## **OXFORDSHIRE COUNTY COUNCIL'S RESPONSE TO CONSULTATION ON THE FOLLOWING DEVELOPMENT PROPOSAL**

**Application no:** 21/03918/F

**Proposal:** Conversion of 2-6 Waterperry Court to a hotel (Use Class C1) including eastern extension, associated car parking, landscaping and ancillary works

**Location:** Waterperry Court, 2-6 Middleton Road, Banbury

Drawing: PROPOSED
BASEMENT
PLAN

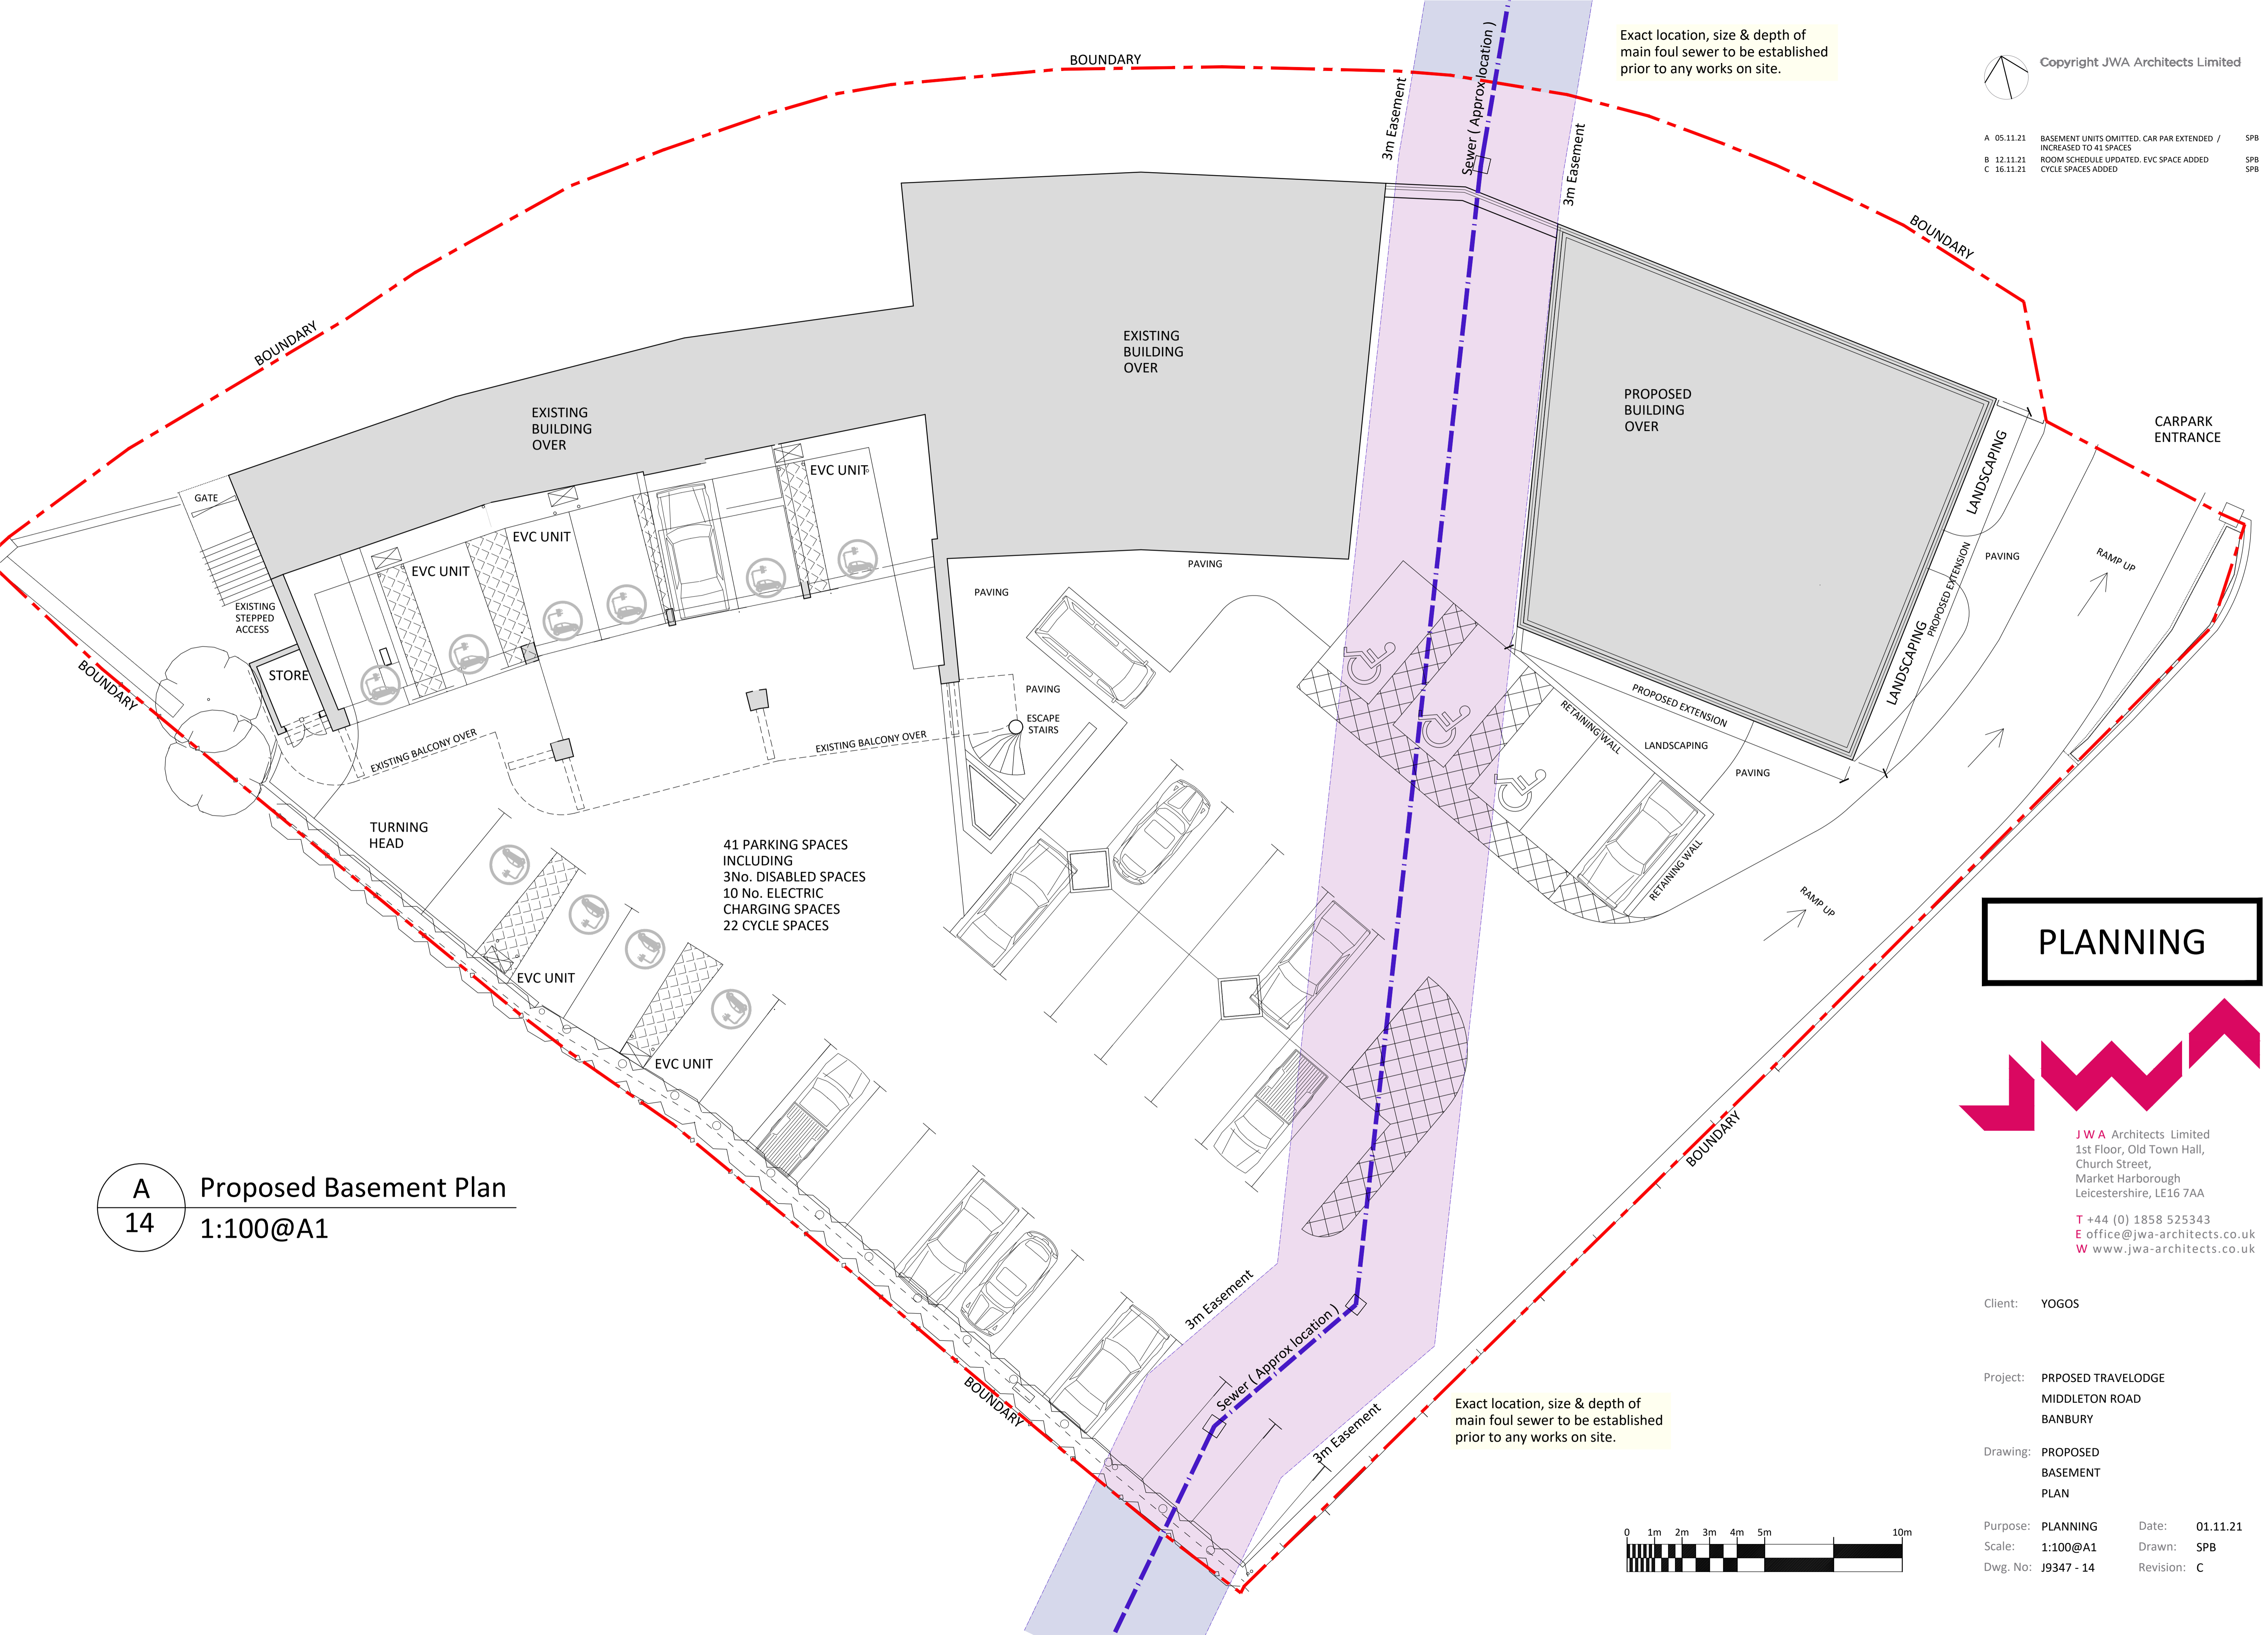
- Prior to commencement of the development, a plan detailing the layout of the car parking area shall be submitted to, and approved by, the Local Planning Authority. The Car Park Layout Plan must set out so that all car parking spaces meet the minimum dimensions required and can be safely and easily accessed. The parking Layout Plan should include a designated coach and Taxi pickup/drop off and parking areas.

**Car and Cycle Parking** -Three of the proposed retained 41 parking spaces are wheelchair accessible. The TA has confirmed that the hotel will not be marketed for coach trips, however parking details of drop off and pick up facilities for coaches should be provided for when this is needed . The LHA welcomes the provision of 25% (10 spaces) of the total parking spaces with electric charging points. The applicant should ensure at least one of the disabled bays has access to an EVC point. A covered, secured and conveniently located 11no. cycle parking stands in compliance with OCC's Policy will be provided for the development.
